DECISION DELEGATED TO DEVELOPMENT MANAGER

Application No: H16-1139-19 **Applicant:** J D S P Dental Ltd

Proposal: Change of use to Dental Surgery - approved under H16-0801-18 - Amendments to internal layout and installation of air conditioning unit on rear wall

Location: Units 1 And 2 Winsover Centre 14-16 Winsover Road Spalding

Drawing
Proposed Ground & First Floor Plans

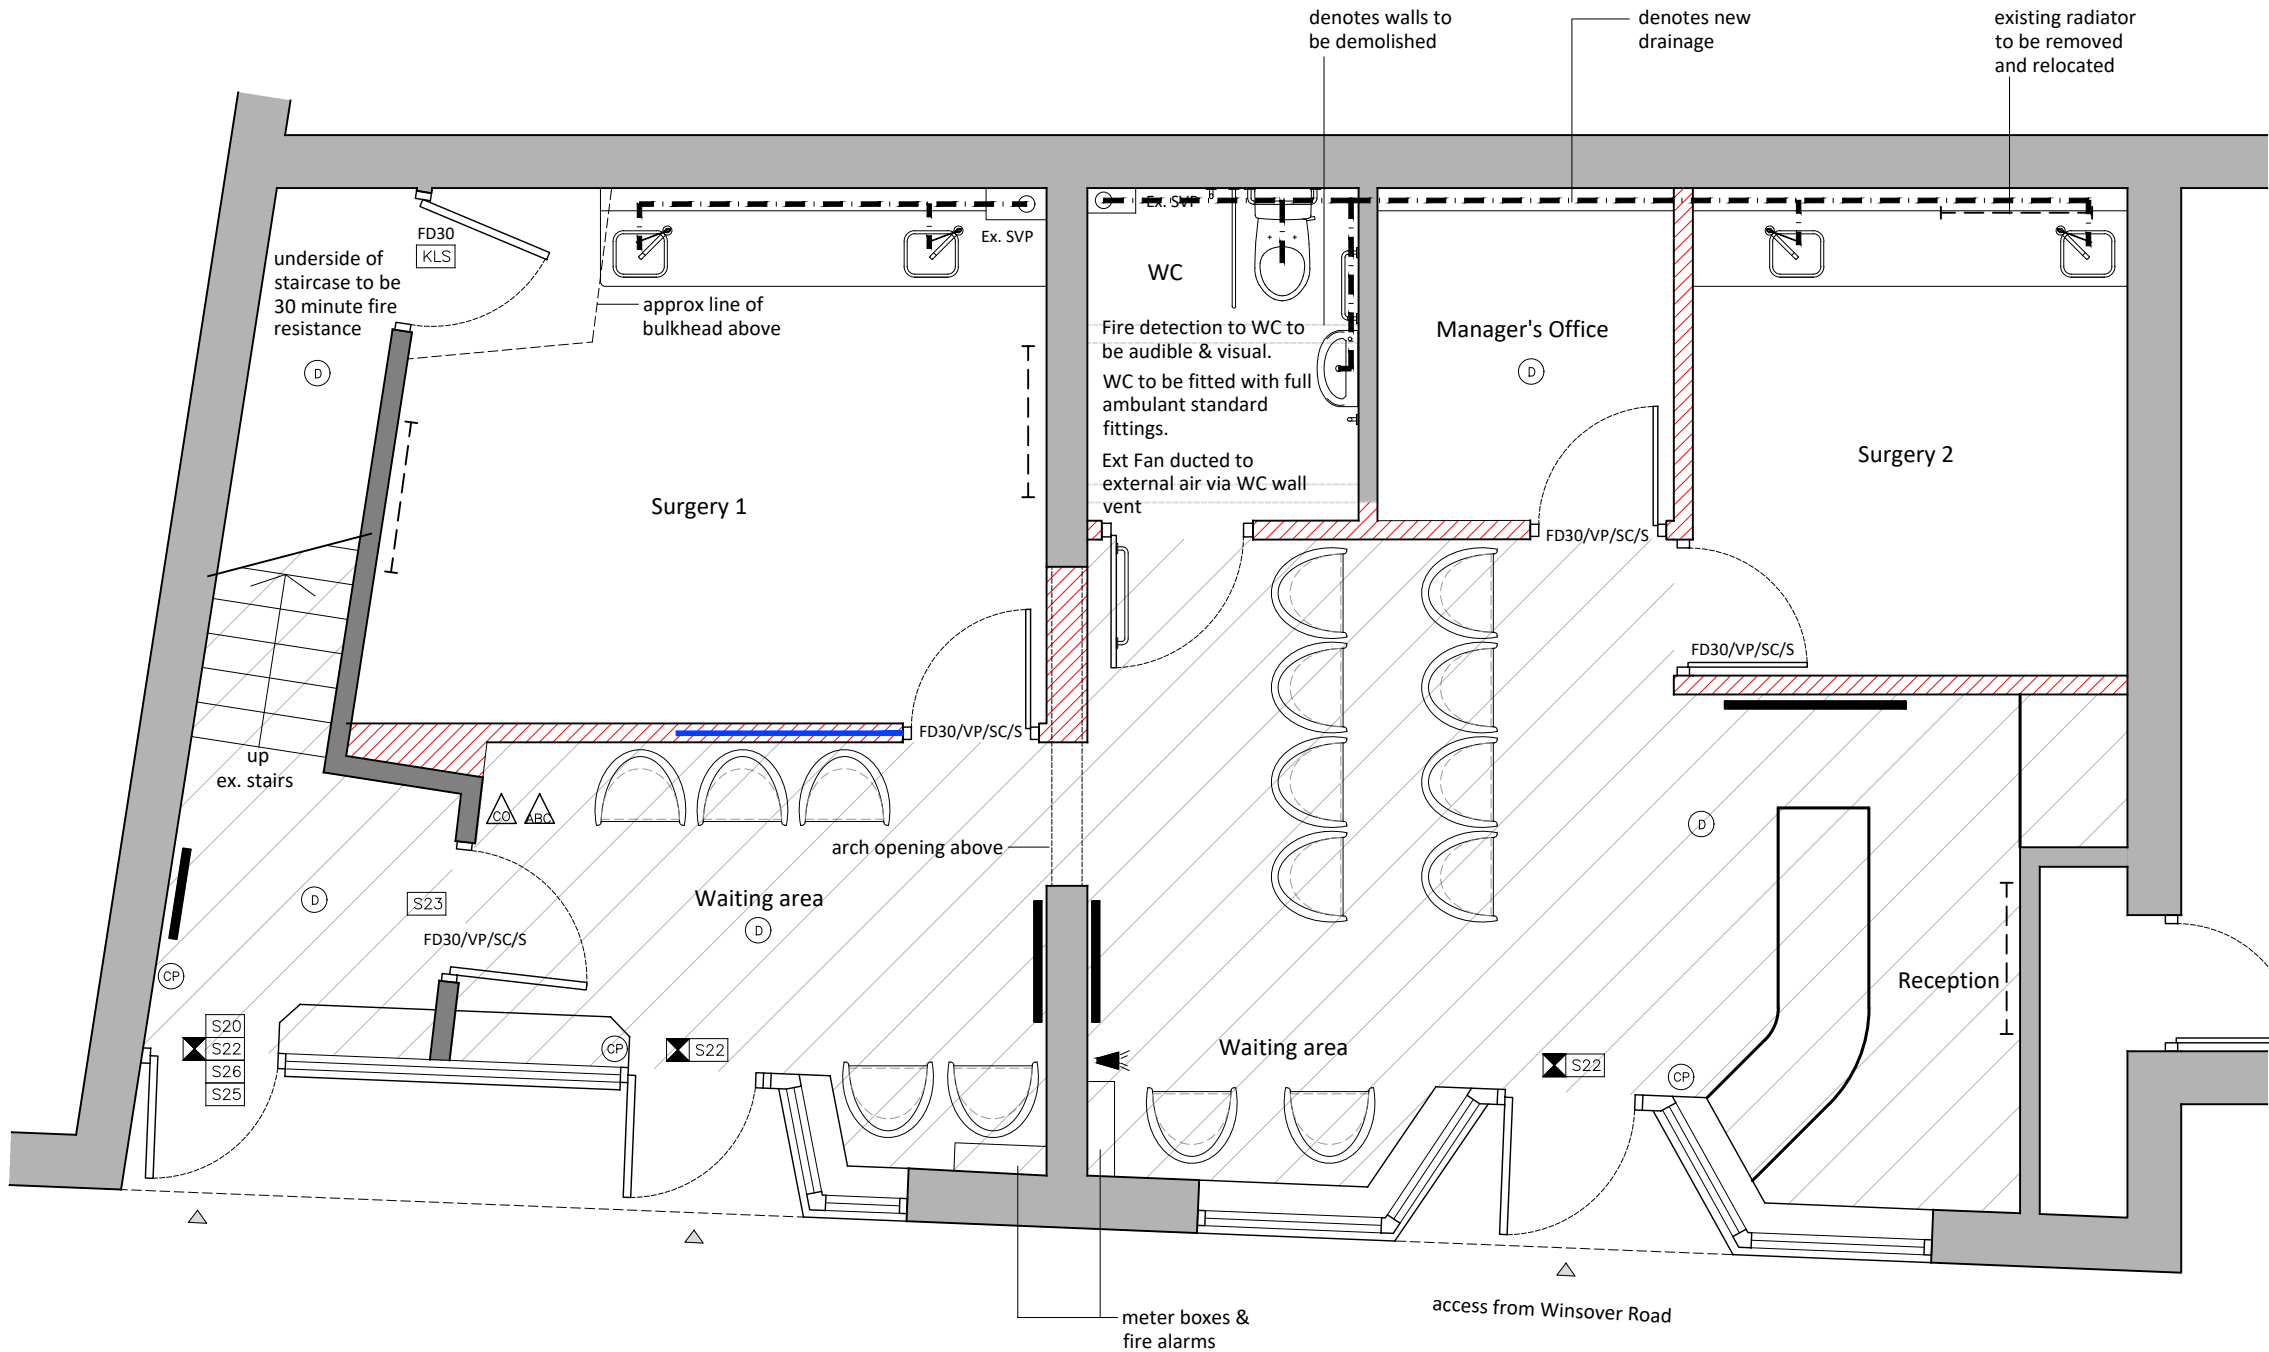
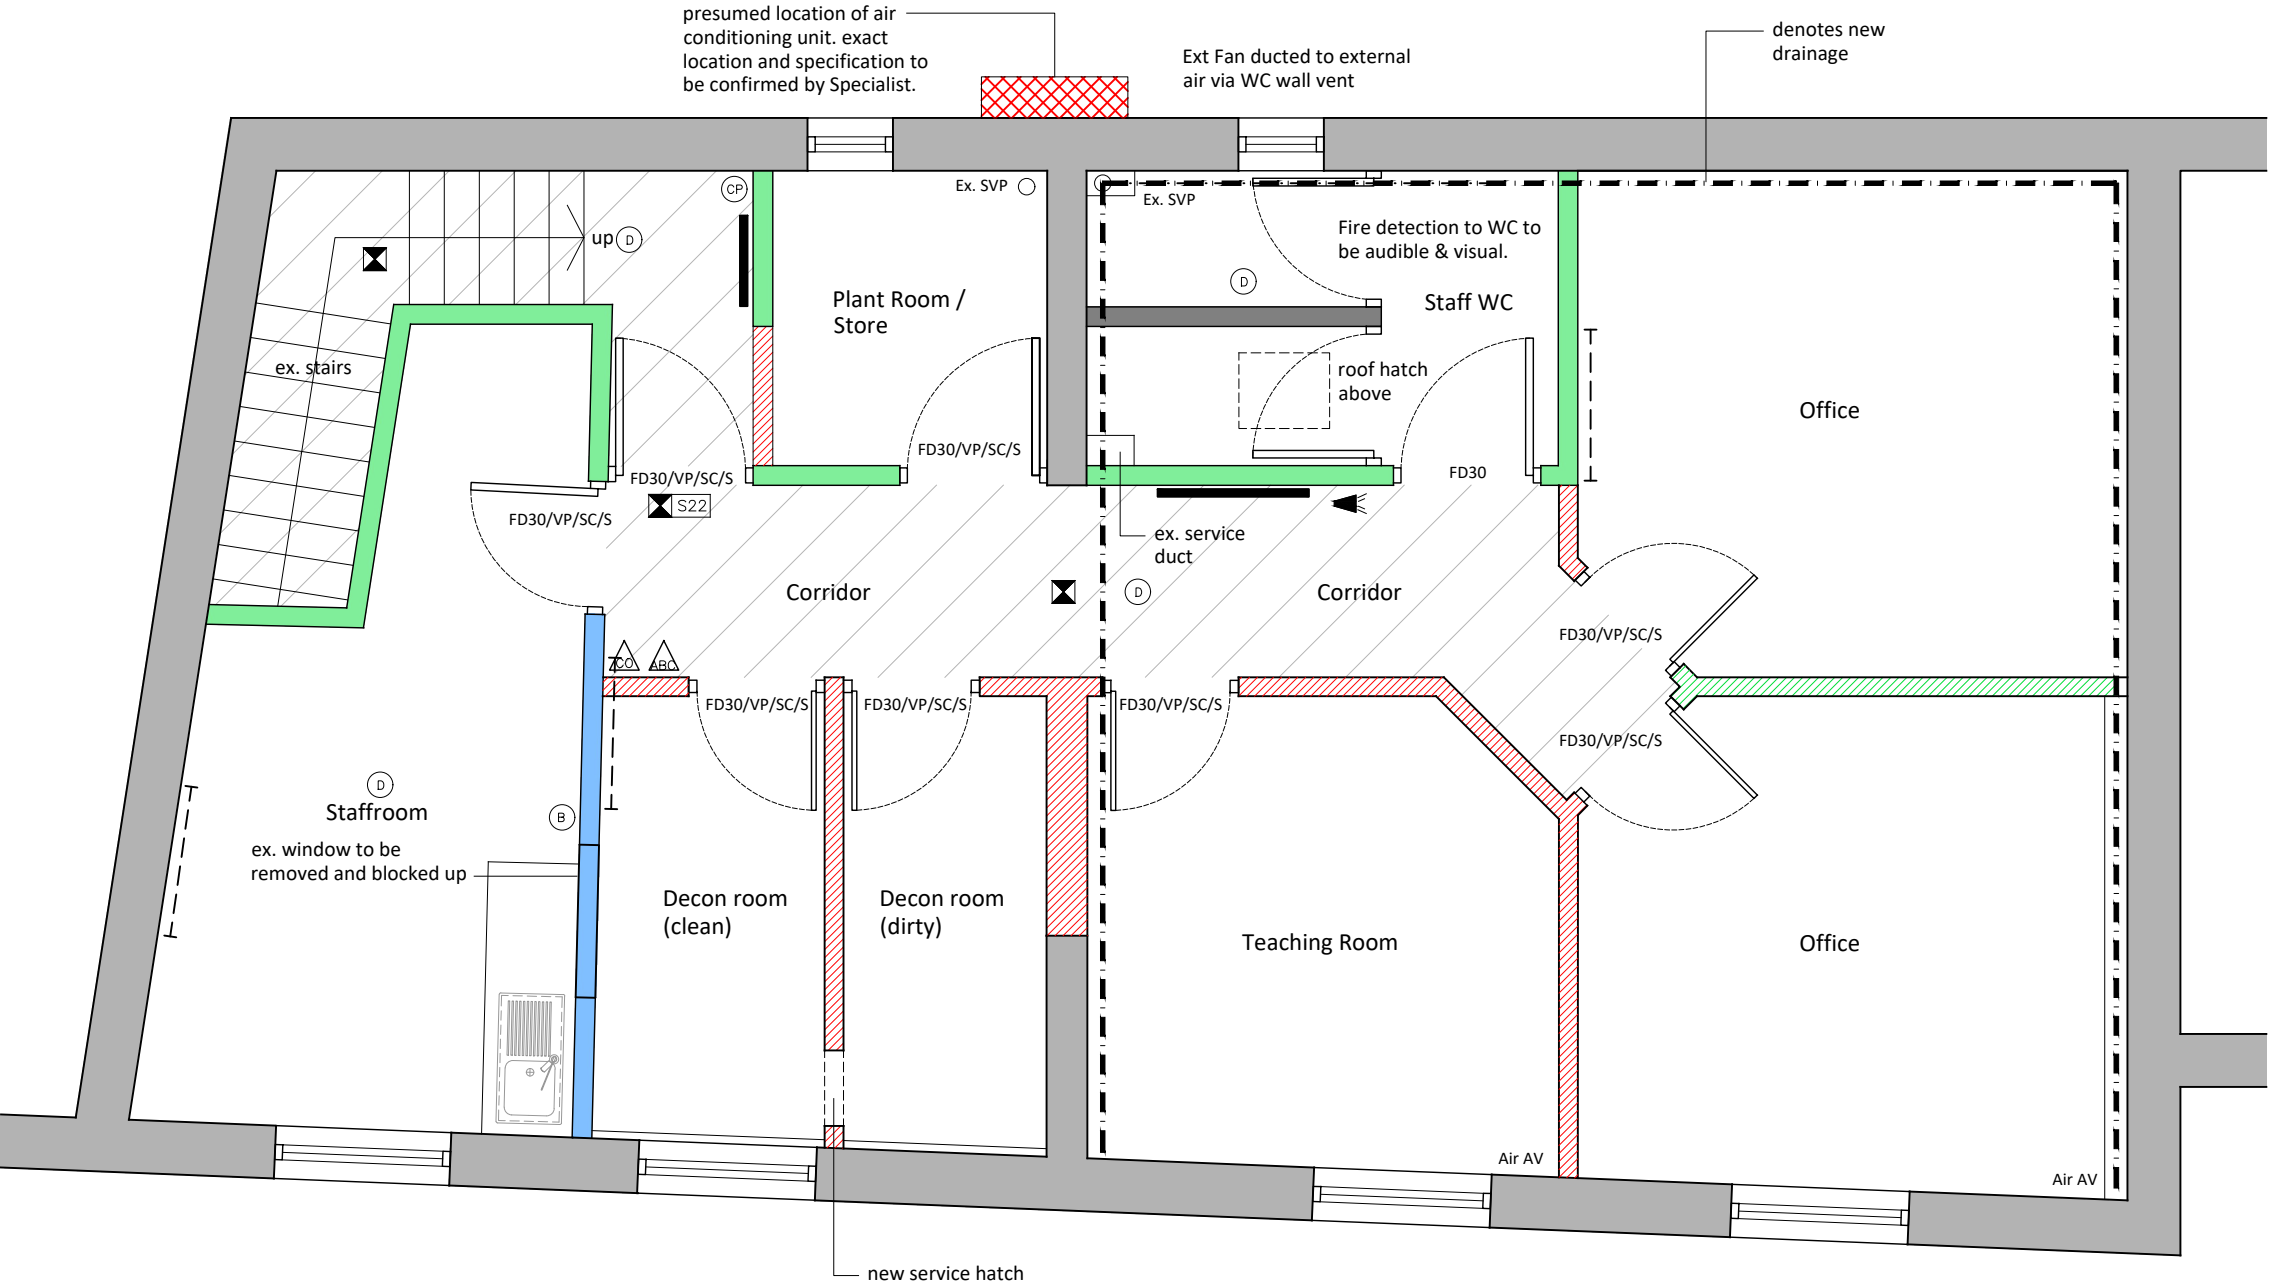
Proposed internal non loadbearing partitioning would be carried out in order to relocate second surgery room on the ground floor level and office on the first floor level. A layer of 12.5mm plasterboard would be applied on the proposed walls. A single air conditioning unit would be externally installed between the two rear windows on the first floor level. The roof of the adjacent unit No. 20 joins the application property and rises away to the north. The surroundings of the air condition unit are characterised by flues down pipes and AC units of other buildings. The proposed works would be acceptable in terms of design and layout.

The proposed walls would be internal so that there would not be any external impact on the building and its street scene. There is a partition wall above the roof with the adjacent No. 20 which would obscure views from the north. There is no other windows with potential overlooking onto the intended AC unit. The area is predominantly retail and commercial. There would not be any harm upon the amenity standards of residents by virtue of visual impact and noise pollution.
